**Town & Country Planning Act 1990 (as amended)
Town and Country Planning (Development Management Procedure) (England) Order 2015
Application for Planning Permission**

Development Demolition of existing garage, demolition of portion of flint wall to re-instate pedestrian access onto Nyton Road & erection of 2 No. dwellings with associated car parking, cycle storage, bin storage & gardens. This application may affect the setting of a Listed Building.

Location Land east of Forge House Nyton Road Westergate

North Elevation: Scale 1:100

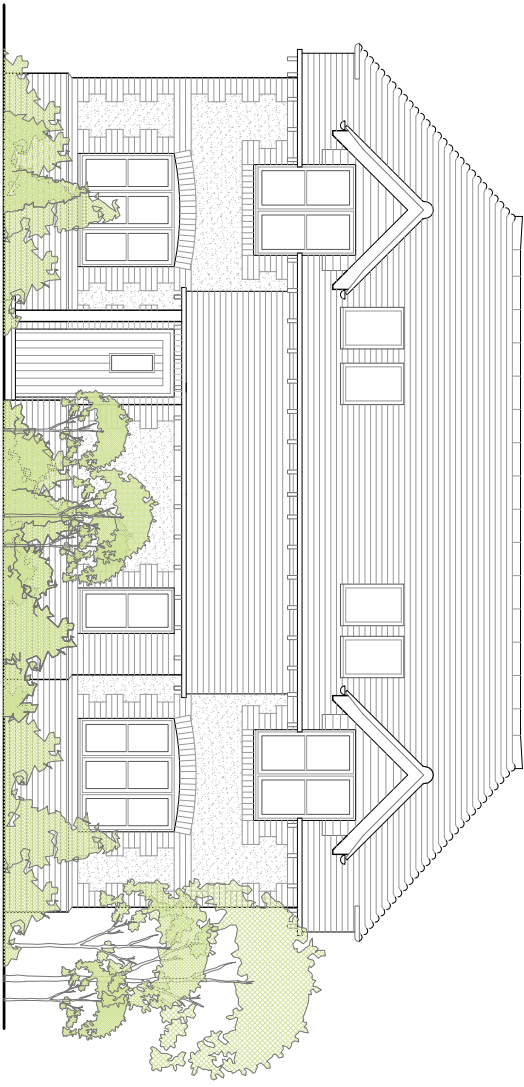
The proposed ground floor and north elevation do not accord. Please amend accordingly.
